TECHNICAL NOTE			
from:	ALAN DAVIES	date:	8/1/2022
subject:	Proposed dwelling with basement accommodation on an in-fill site adjacent to no 9 Old Road Chatburn 3/2021/1153	file ref:	J1050-TN1

A detailed planning application has been submitted, this has been reviewed and clarification is sort on the drive and sight lines.

This Technical Note sets out the response to the feedback.

Proposed Site Plan 1:200

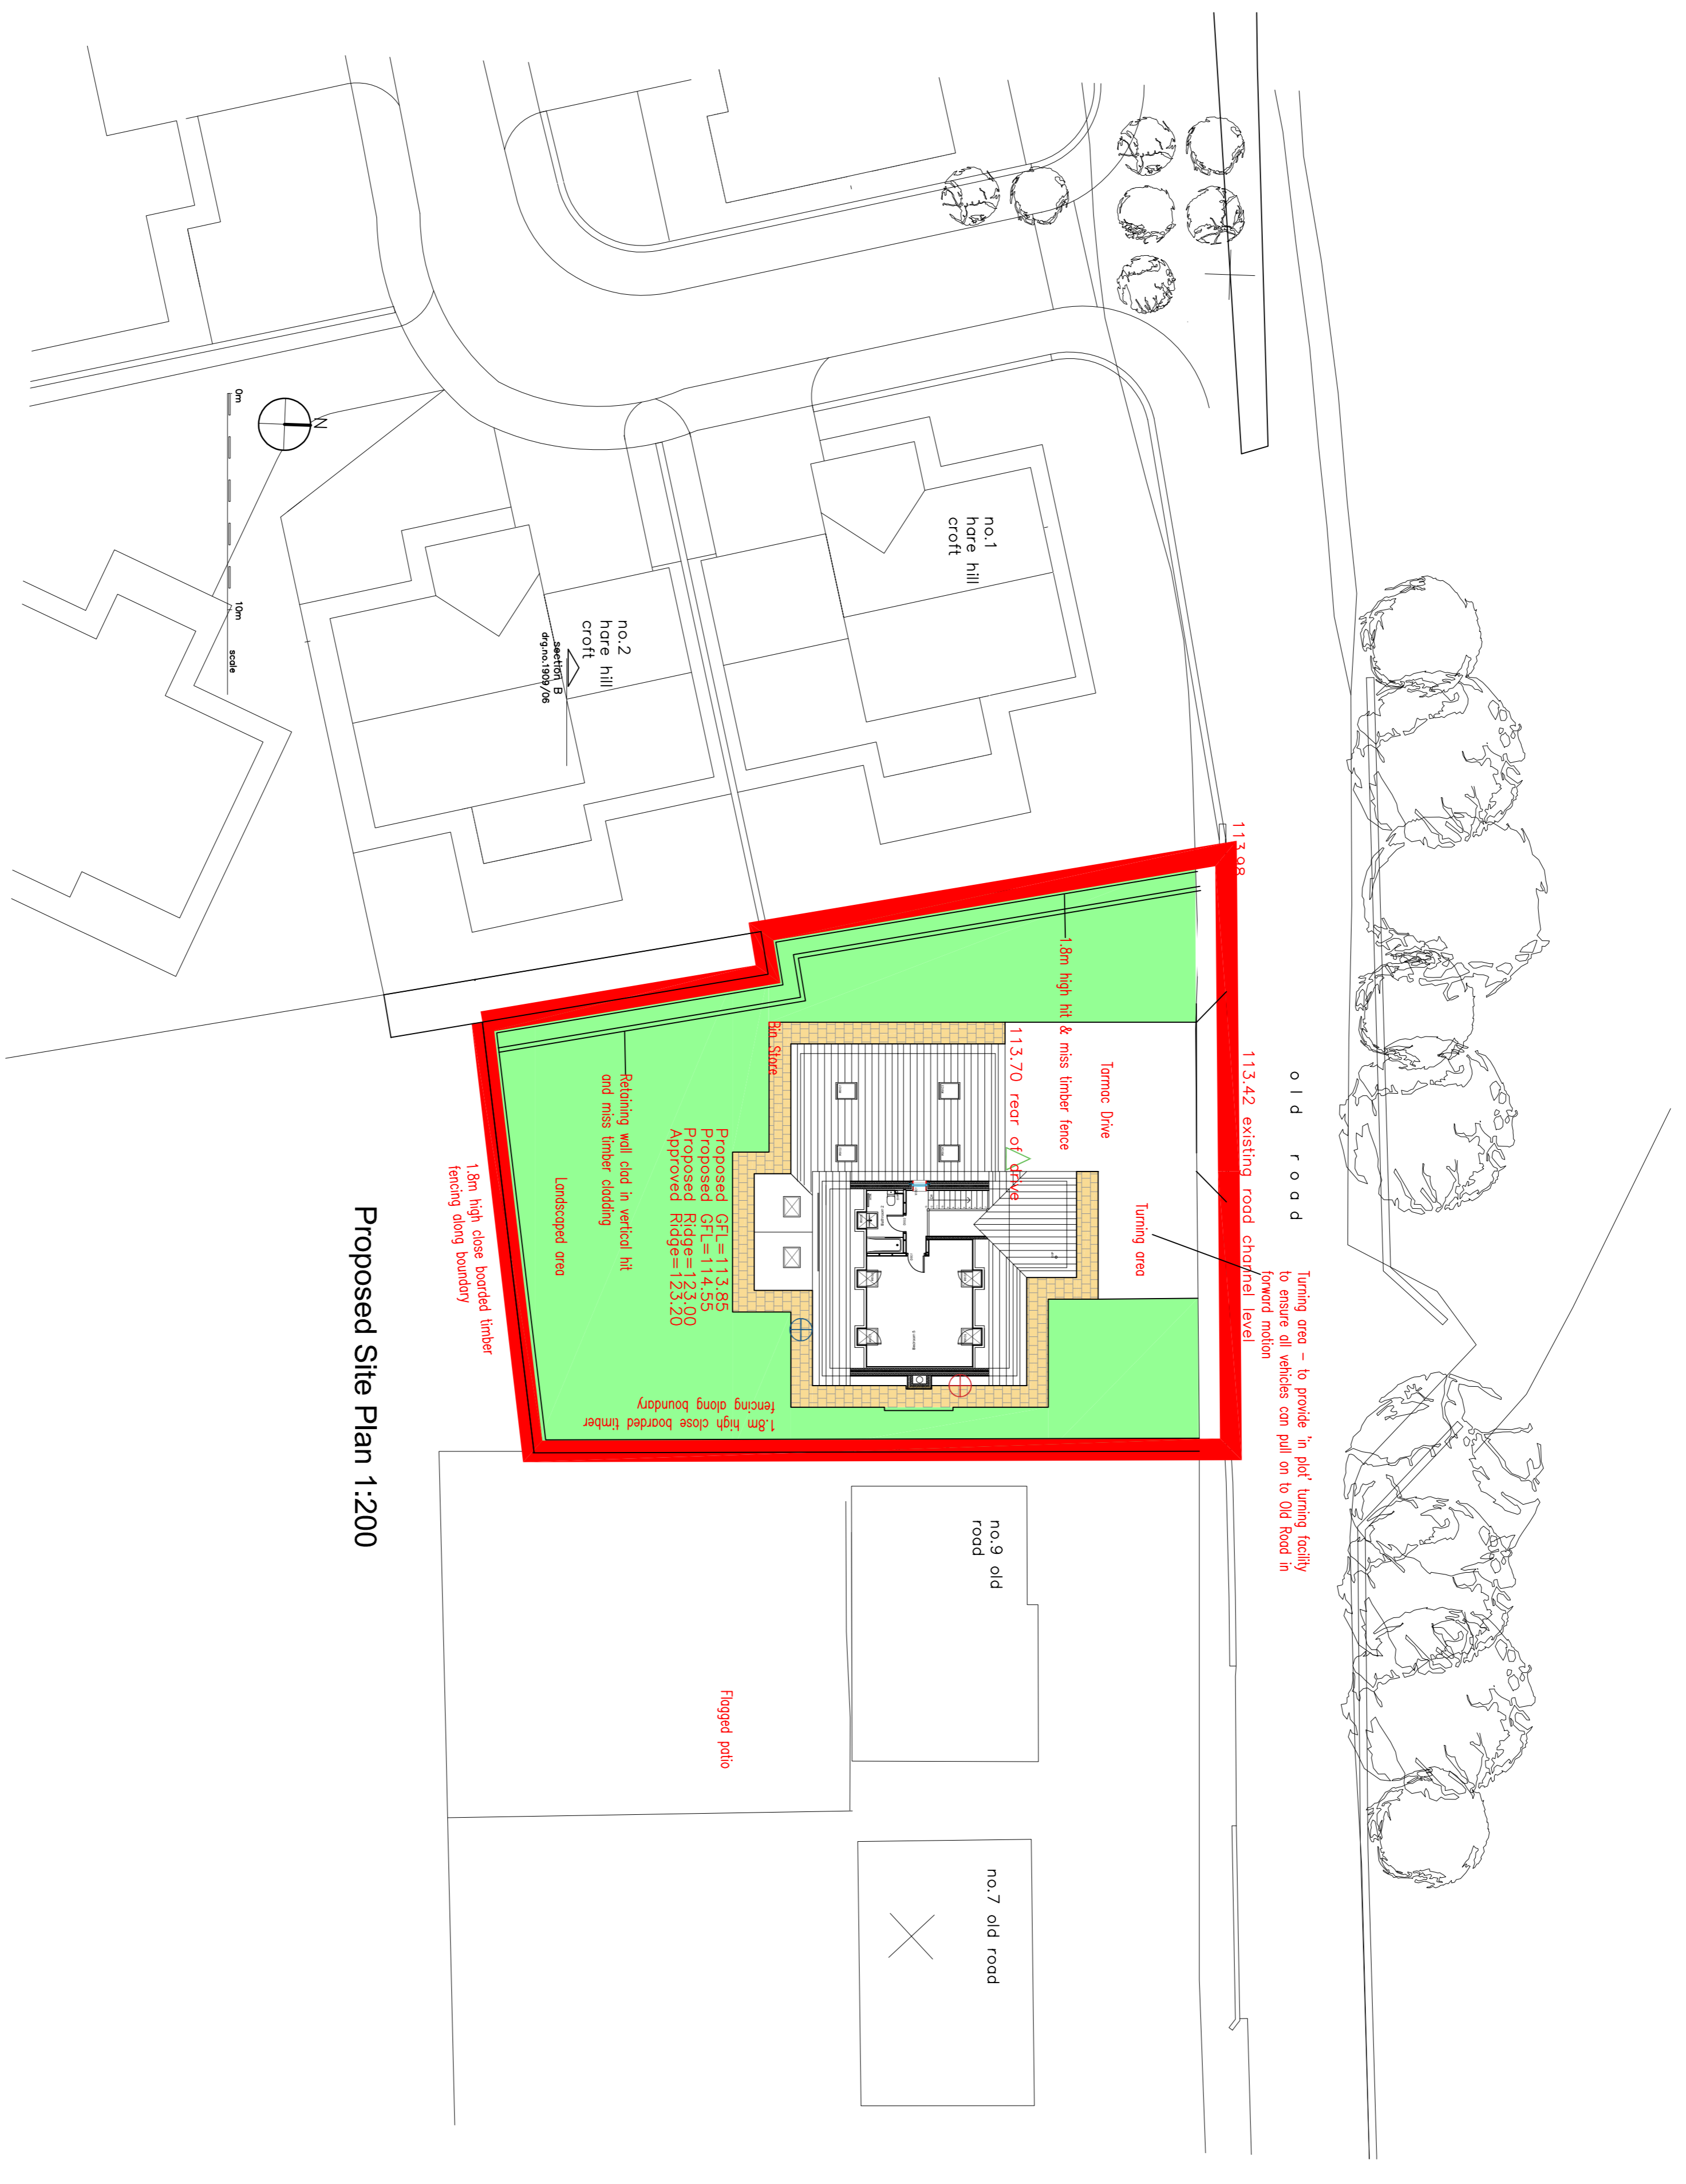
Furthermore, the LHA have reviewed Stanton Andrews drawing number 02 Rev F titled "Site Plan As Proposed" and are aware that there will be a 1.8m high fence to the right of the access, separating the proposed dwelling and number 9 Old Road.

The LHA are aware that the 1.8m high fence will be located within the site's visibility splays. Therefore, the LHA remind the Agent that should a revised drawing showing the sites visibility splays be submitted and the LHA accept the drawing, the LHA will condition that anything within the splays is reduced to a height no higher than 0.9m to allow for vehicles to clearly view the public highway. This will include reducing the height of the fence.

The LHA have reviewed Stanton Andrews drawing number 02 Rev F titled "Site Plan As Proposed" and are satisfied that the parking arrangements complies with the LHAs guidance as defined in the Joint Lancashire Structure Plan. Therefore, the LHA have no further comments to make regarding parking

Irrespective of the sight lines to be agreed the fence etc will be reduced in height or set back to ensure it does not affect the visibilities set out.

The agreement to the internal layout is appreciated.

By providing a 6m wide drive and a build out to the right side on exit as shown the sight lines are increased and the vehicle is offset from the boundary wall.
